CITY OF ALBUQUERQUE
 PLANNING DEPARTMENT
 DEVELOPMENT REVIEW BOARD

Project# 1009506

- 13DRB-70758 VACATION OF PUBLIC EASEMENT
- 13DRB-70759 - TEMP DEFR SWDK CONST
- 13DRB-70760 MAJOR - PRELIMINARY PLAT
- 13DRB-70761 SITE DEVELOPMENT PLAN FOR SUBDIVISION
- 13DRB-70762 VACATION OF PUBLIC RIGHT-OF-WAY

BOHANNAN HUSTON INC agents for PULTE HOMES OF NEW MEXICO request the referenced/ above actions for Lots 14-19, **VOLCANO CLIFFS UNIT 6 (tbka MONTECITO WEST UNIT 2)** zoned SU-2 VOLCANO CLIFFS RURAL RESIDENTIAL (VCRR), located on ALBERICOQUE PL NW between VISTA VIEJA NW and SCENIC RD NW containing approximately 16.54 acres. (D-9)

Plat for  
**Montecito West, Unit 2**  
Being Comprised of  
Lot 14, Volcano Cliffs Subdivision Unit 6 and  
Tract A, Montecito West, Unit 1, Together with A  
Portion of Vacated Villa Real Road NW Right-of-Way  
City of Albuquerque  
Bernalillo County, New Mexico  
December 2014

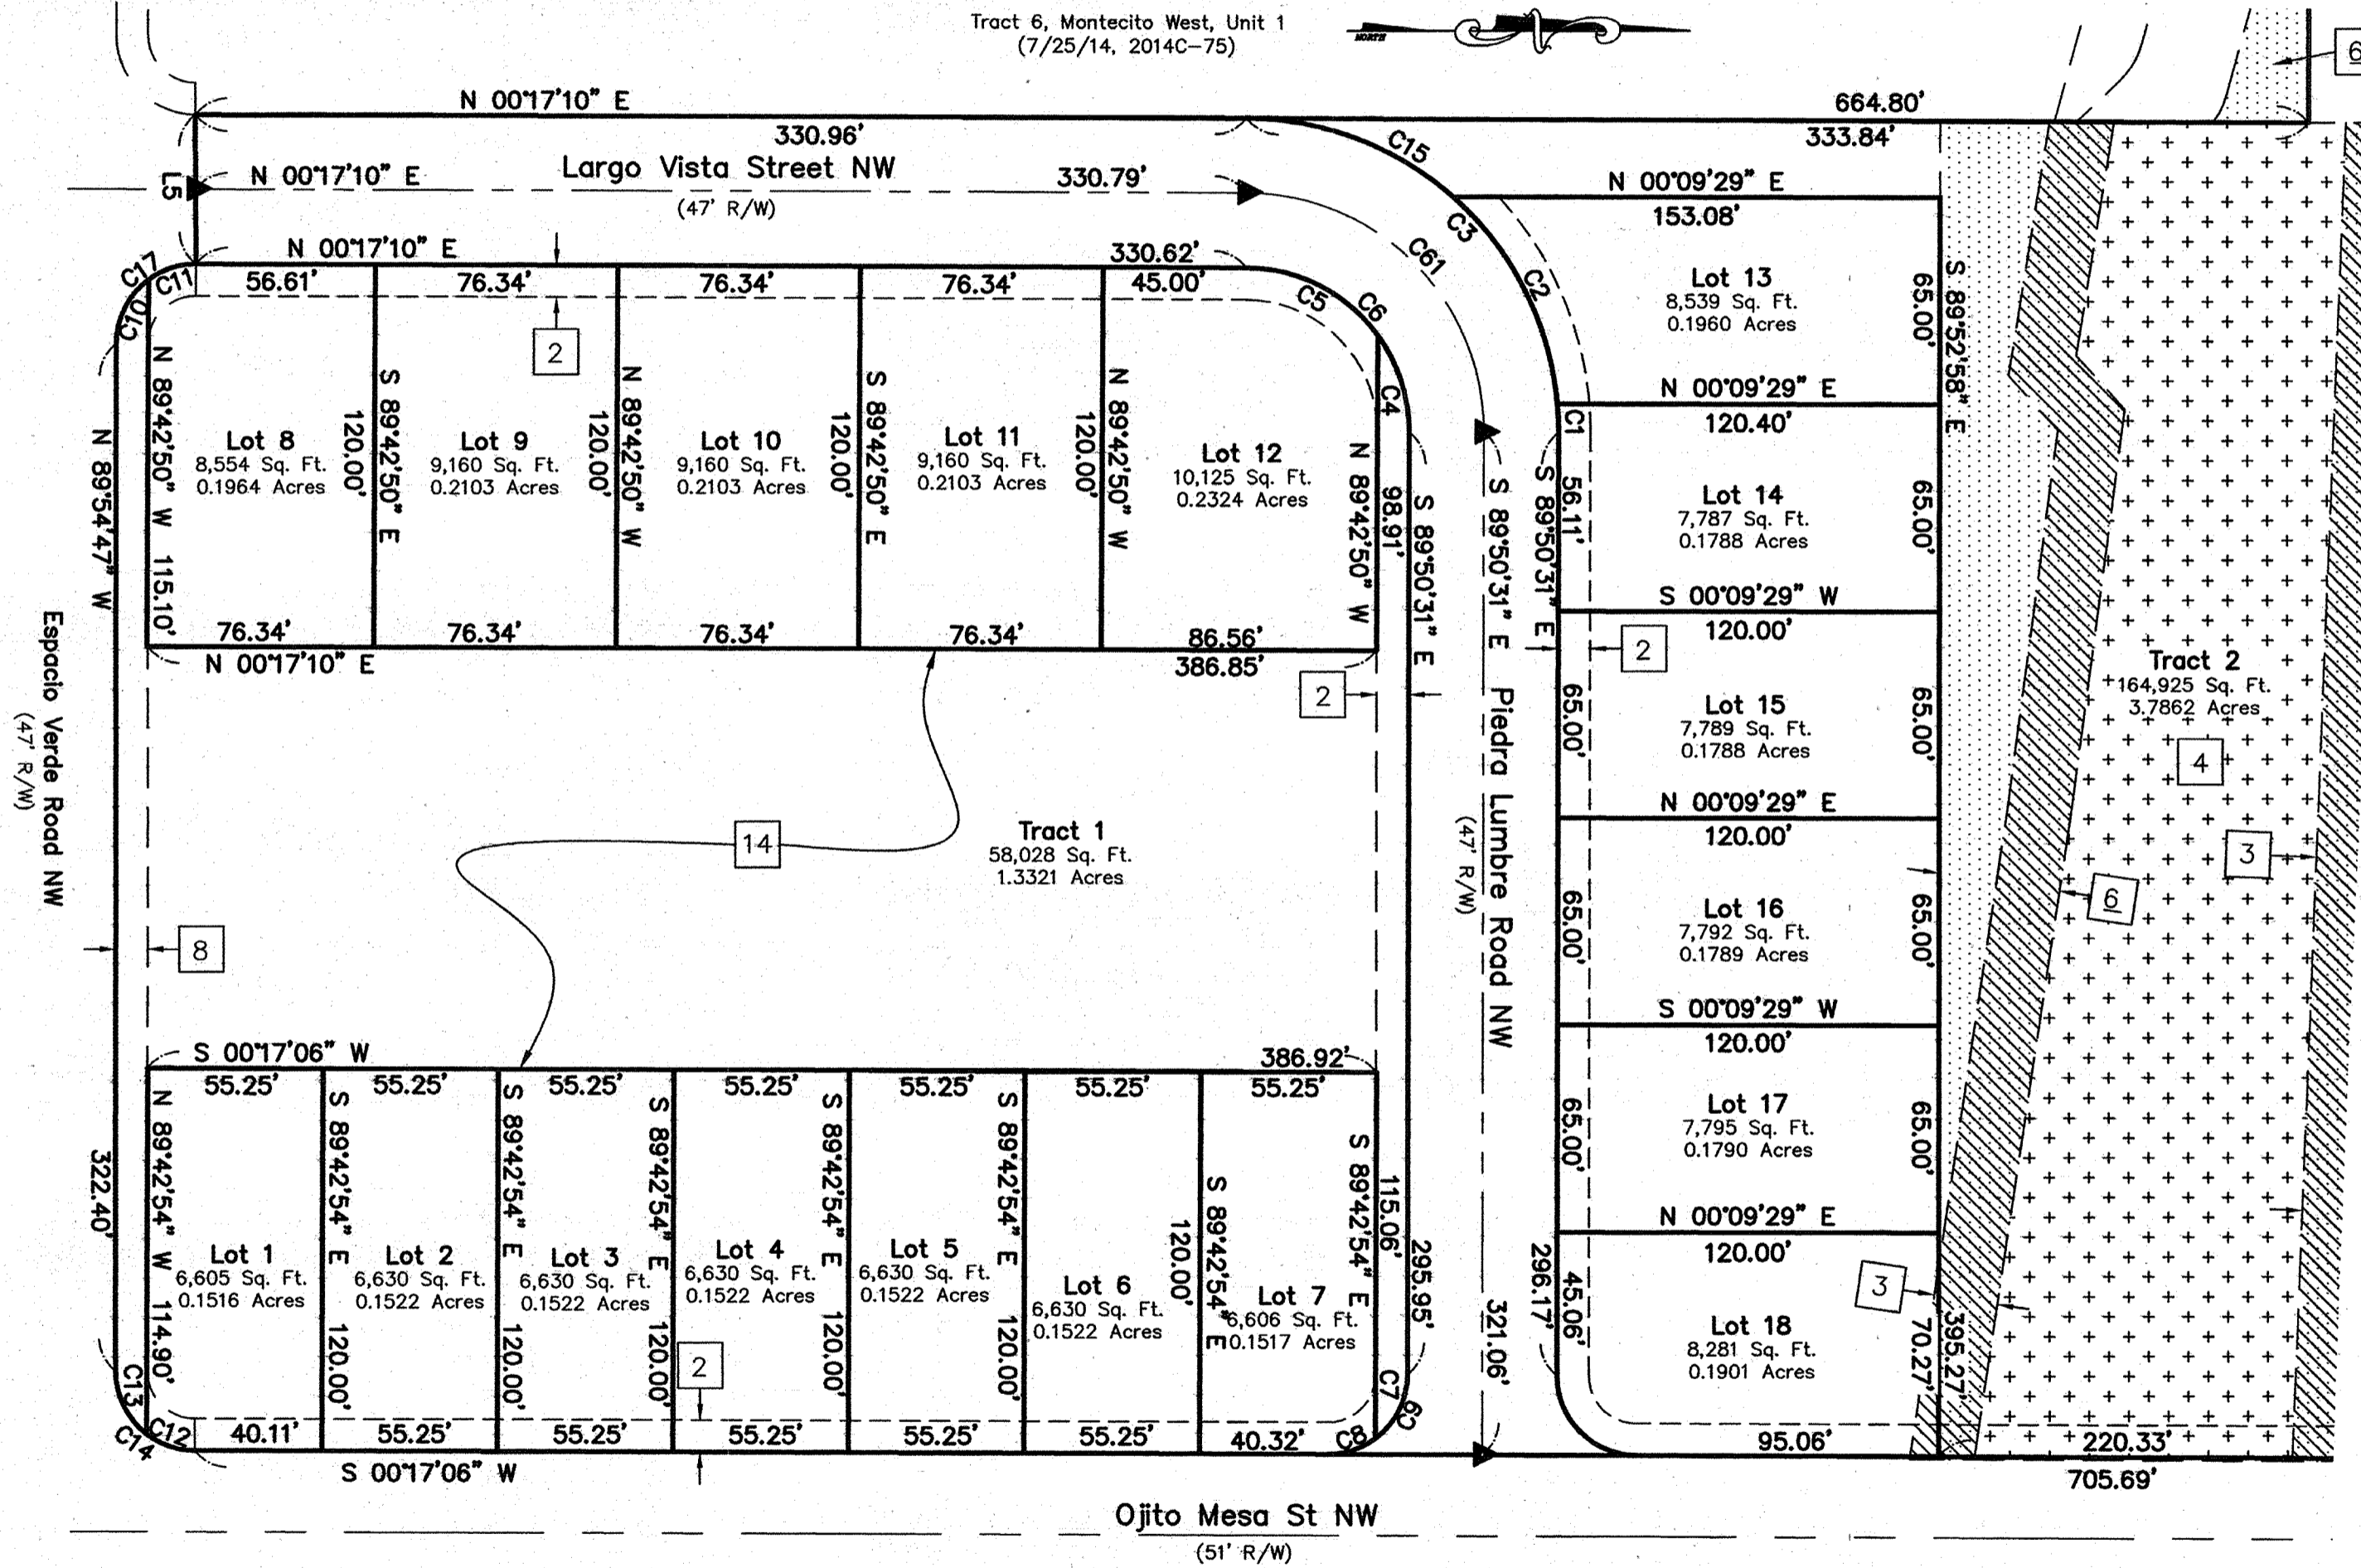
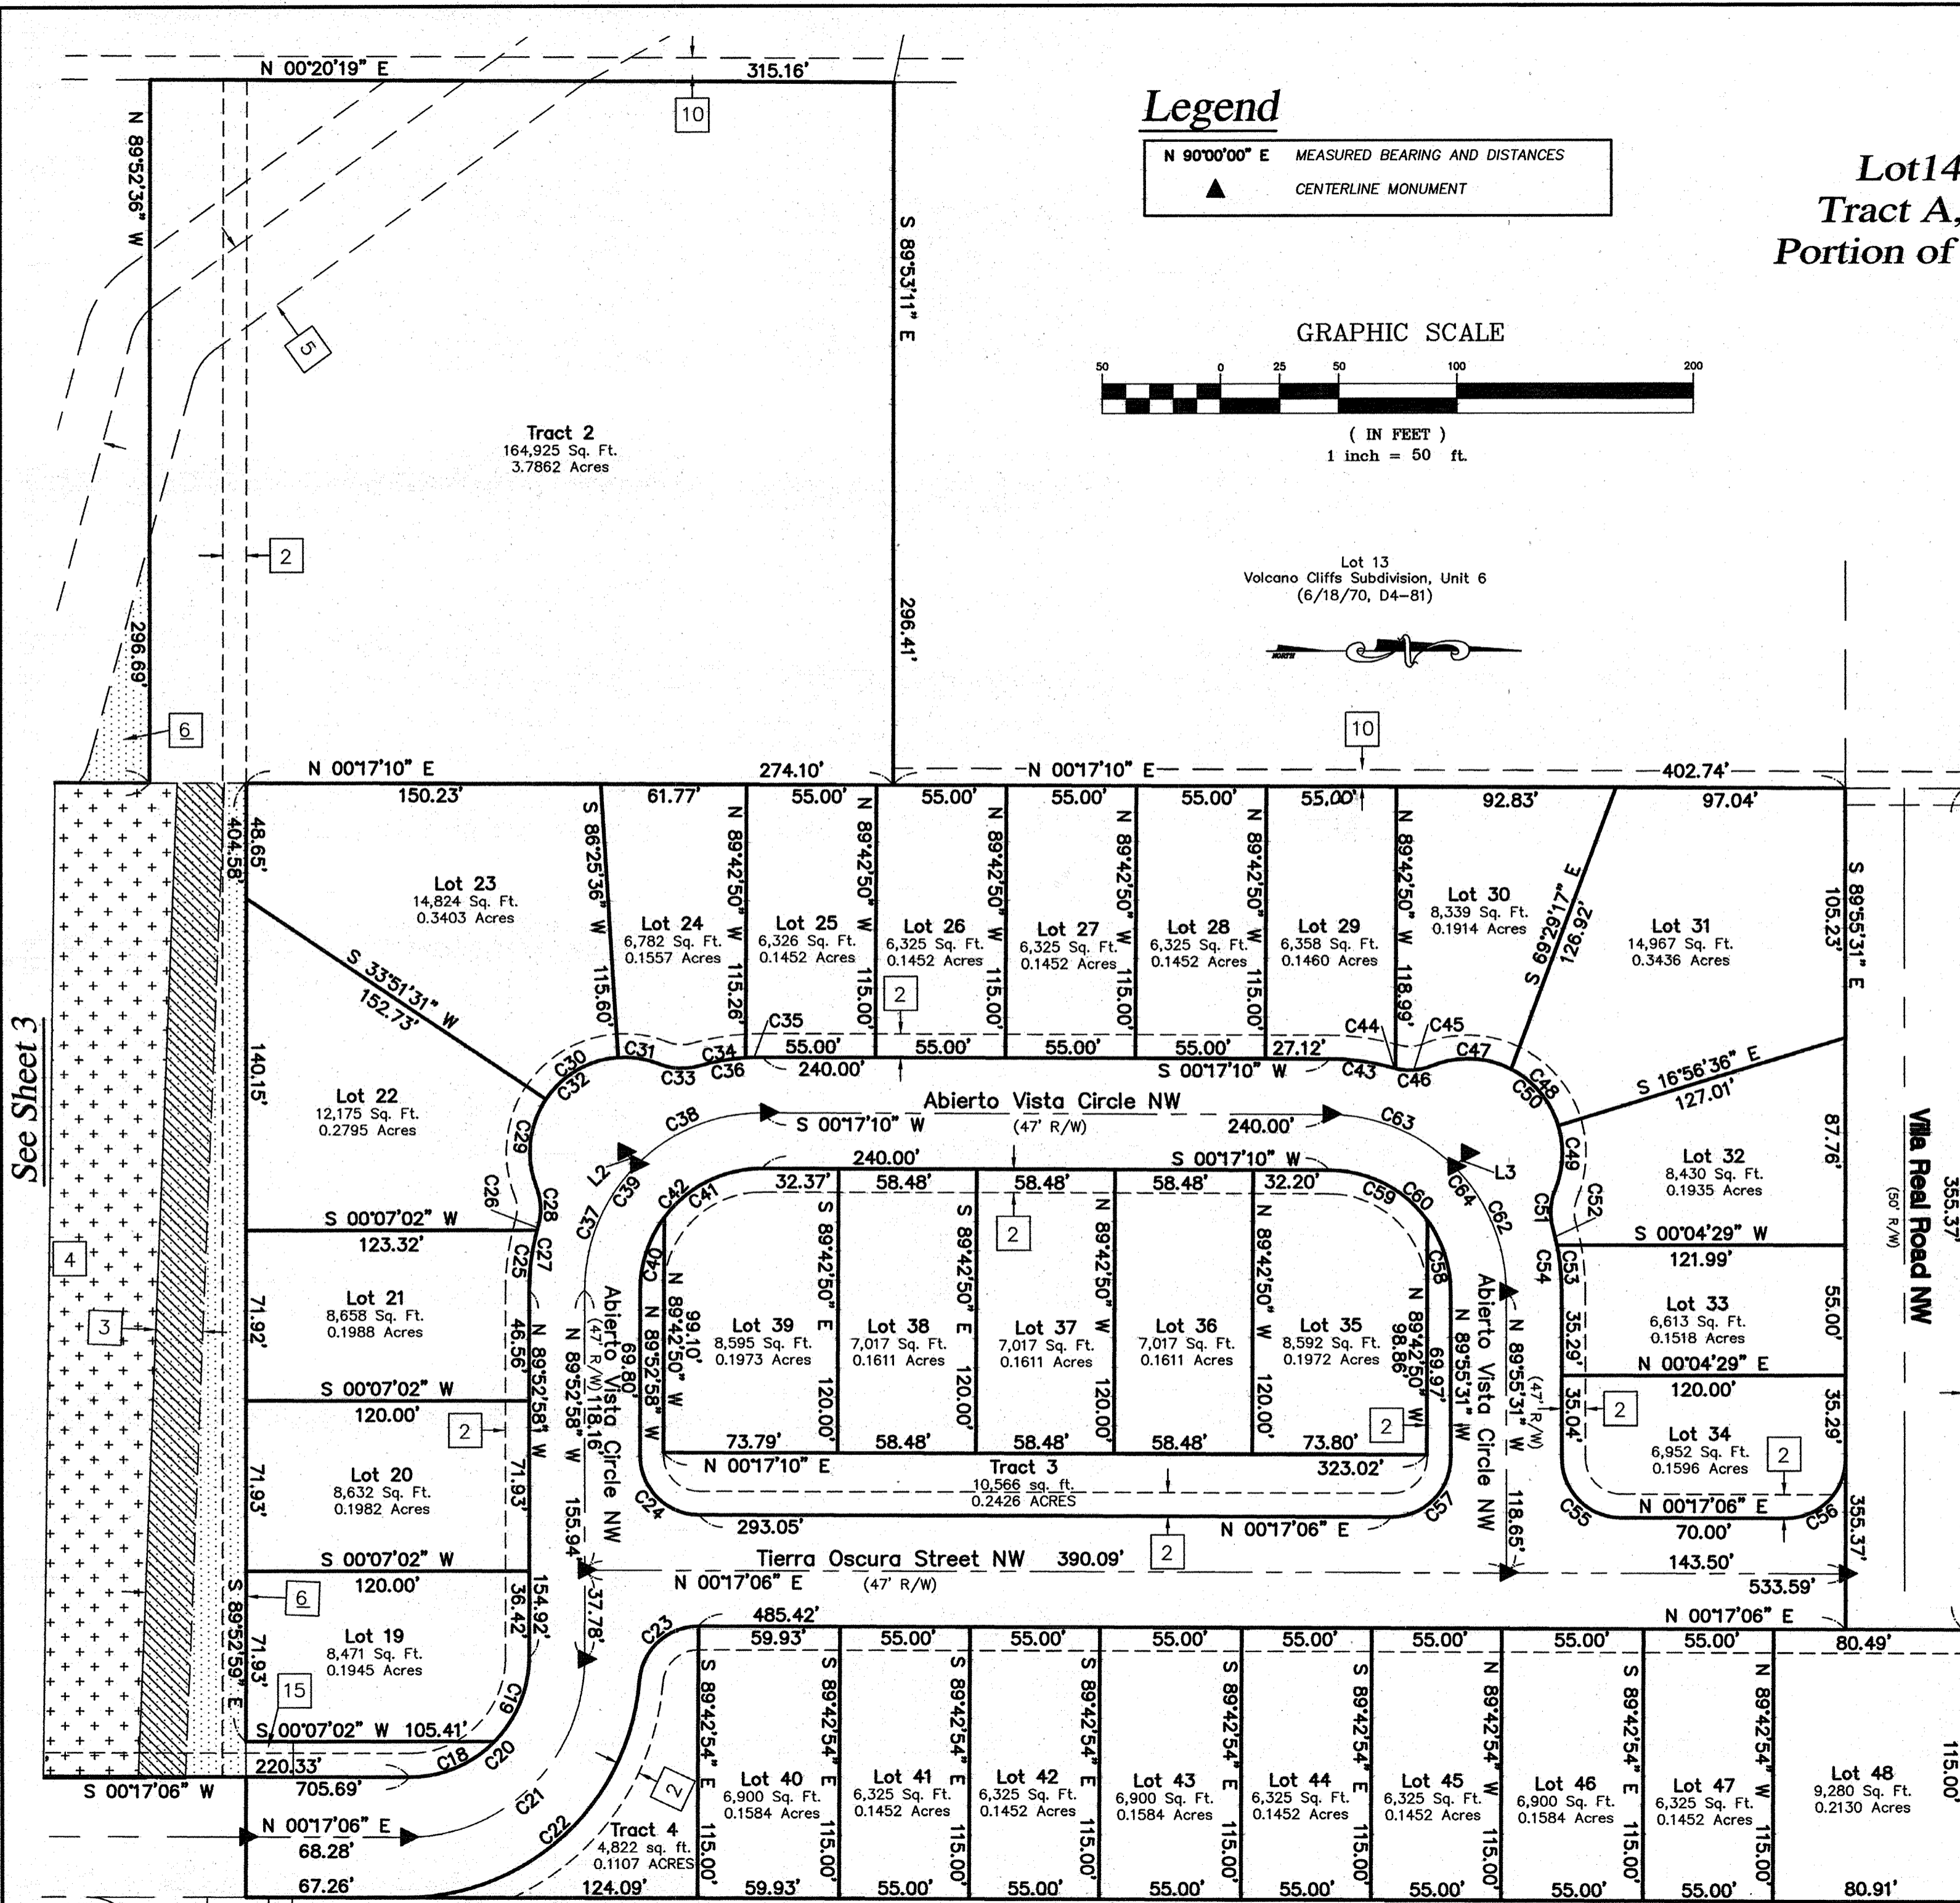
- a. More information is needed regarding the 2 HOA tracts and the 2 Private Common Area tracts.
- b. Parks & Recreation's Open Space Division requests that the Parceled Commons Areas Tracts 1 and 2 be dedicated to the City to be managed as public Open Space by the Open Space Division. Please change General Notes #6 to reflect this change.

- c. The Public Open Space will need to be fenced with open space fencing prior to construction of adjacent infrastructure and residential lots to prevent damage to existing vegetation. Fencing to be added to Infrastructure List.

- d. Please change all references to Private Commons Areas (PCA) as the name has been changed to Parceled Common Areas (PCA) within Private Commons Development (PCD). Per the Ordinance, Parceled Common Areas can be Public or Privately owned and maintained. In this request, the Parceled Commons Areas shall be Public Parceled Commons Areas.

- e. Provide note in General Notes stating the responsibility of the HOA to maintain the 2 HOA tracts.
- f. Line weights in the Legend are difficult to differentiate on the Plat.
